**PLANNING AND INFRASTRUCTURE**  
Planning Unit

Re: State Significant Development Application Number SSD-76555711  
Mixed use infill affordable housing: 3-5 Help Street, Chatswood  
Response to Submissions

Appendix D

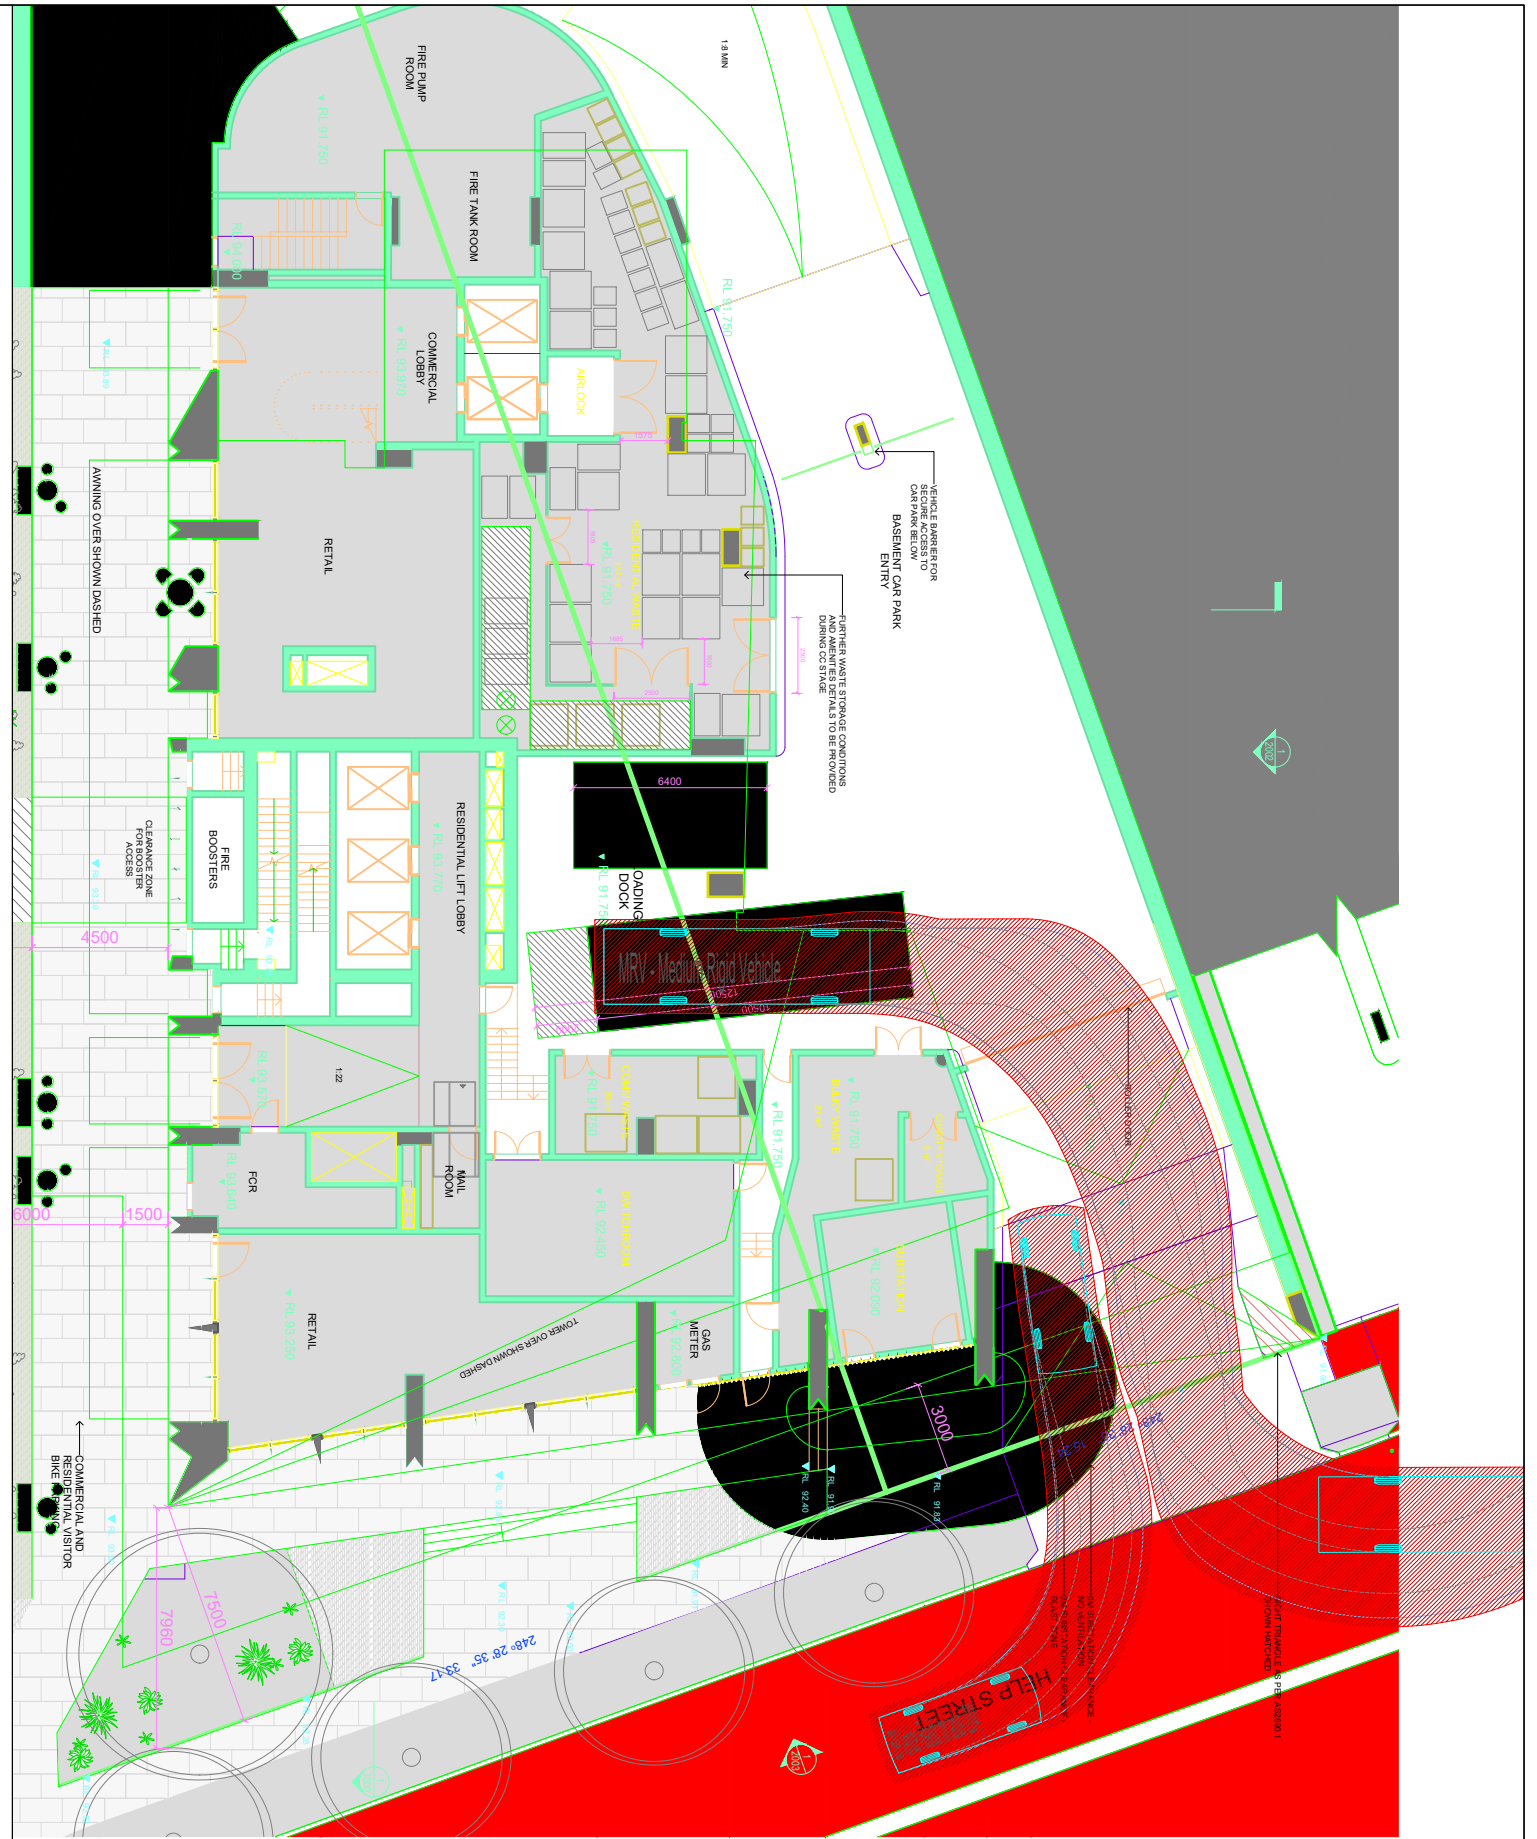
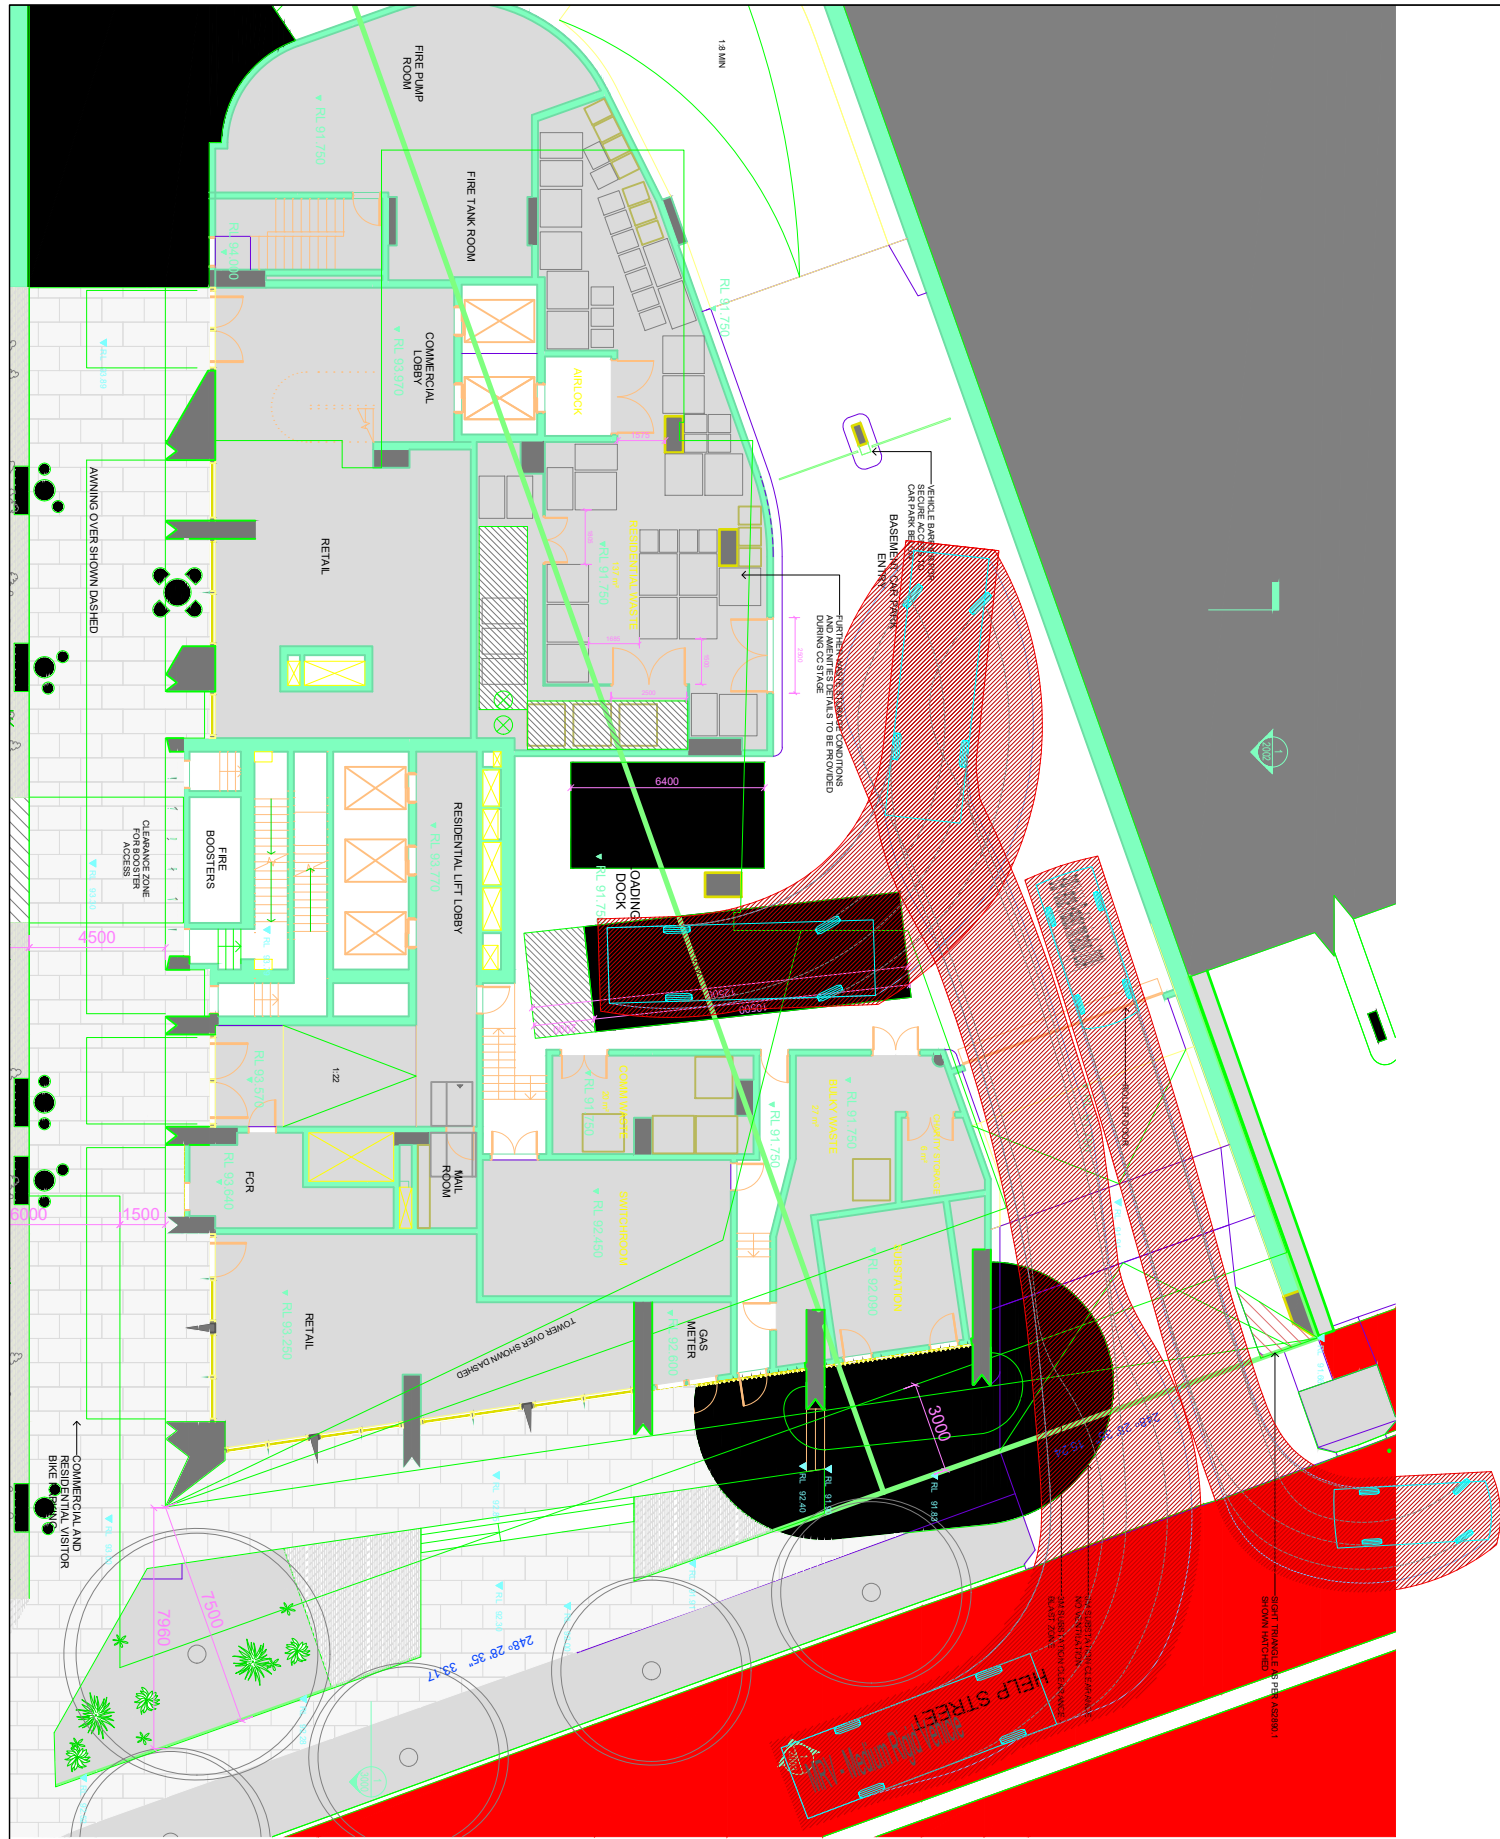
Willoughby City Council has developed a schematic design for the works that will be required to ensure vehicles, including waste and delivery vehicles are able to safely access the site, noting the current intersection of Help Street and Cambridge Lane, and the current configuration of Cambridge Lane and of McIntosh Street require upgrades to accommodate the proposal and avoid dangerous conflicts between vehicles, cyclists and pedestrians.

Cambridge Lane, and its intersection with Help Street, is required to be upgraded to more safely accommodate larger vehicles, and remove conflicts with cyclists.

The development should be conditioned to provide public domain upgrades to Council's satisfaction, upgrading Cambridge Lane, including its entry point from Help Street, and implementing the no right turn arrangements specified above.

*Construction Plans for Public Domain Upgrades are to be approved by Council prior to the issue of a Construction Certificate. The works should include, to Council's specification, raised thresholds, road paving, landscaping and signage upgrading of McIntosh Street, Help Street and Cambridge Lane. Cambridge Lane and McIntosh Street are to be a shared zones.*

*Public Domain Upgrades on McIntosh Street, Help Street and Cambridge Lane are to be constructed to Council's satisfaction prior to the issue of an Occupation Certificate.*
